Our Reference: SYD15/01390/03 (A20958435)
DP&E Ref: SSD 7348

CONCEPT PROPOSAL FOR STAGED DEVELOPMENT OF OAKDALE WEST ESTATE (OWE) AND STAGE 1 DEVELOPMENT INCLUDING CONSTRUCTION OF WESTERN NORTH SOUTH LINK ROAD (WNSLR) - KEMPS CREEK, PENRITH

Figure 5: Lenore Drive / WNSLR intersection (Additional Upgrades) – 2036 Modelling Scenario

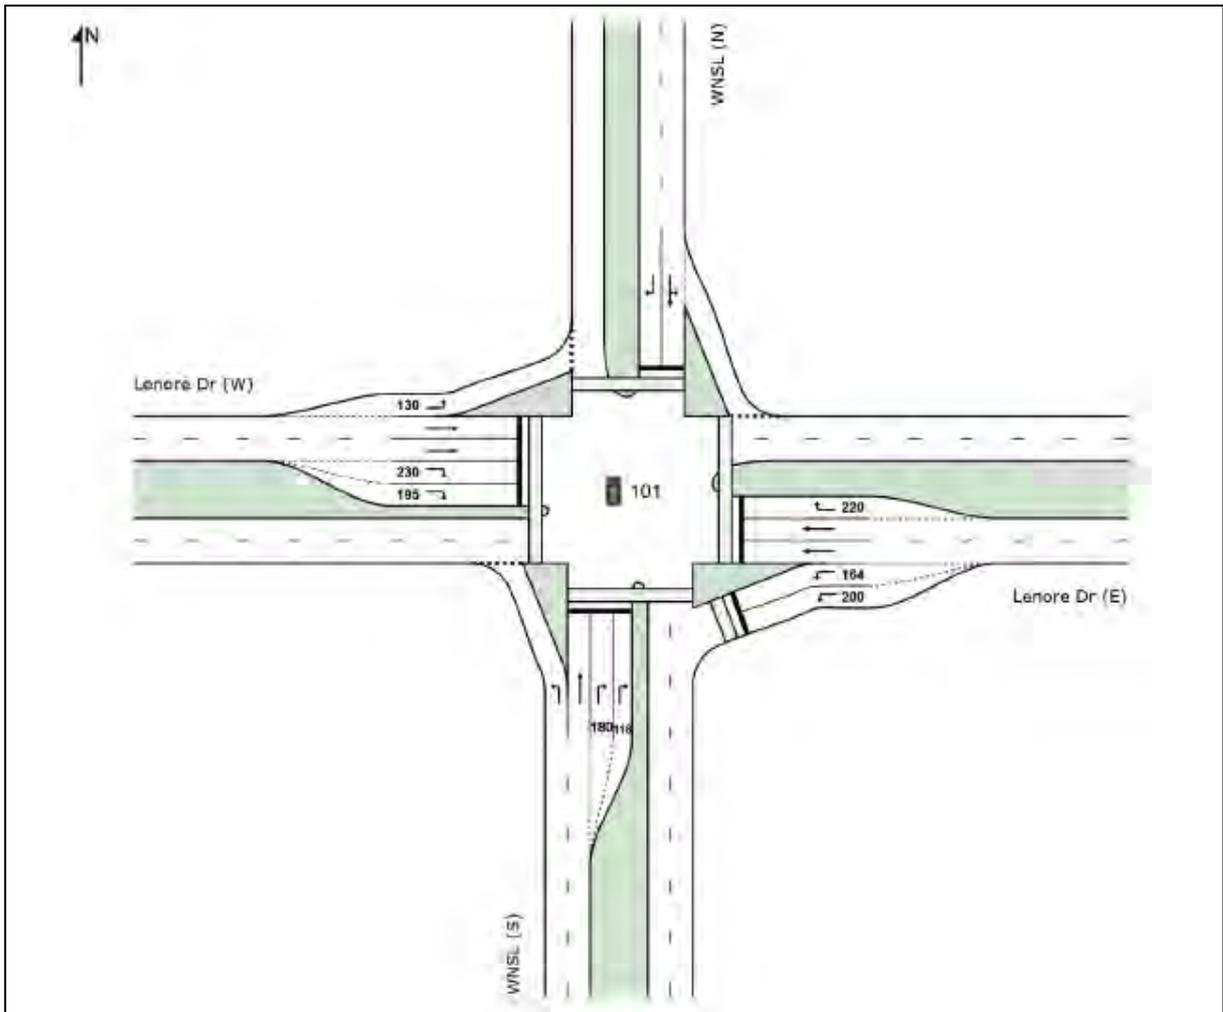
6. The construction of the signalised intersection of Lenore Drive and WNSLR is to incorporate sufficient space to accommodate future improvements including an additional right turn lane for eastbound traffic on Lenore Drive into WNSLR, and for an additional left turn lane for westbound traffic on Lenore Drive turning south onto WNSLR. This allows for future forecast traffic volumes up to 2036.
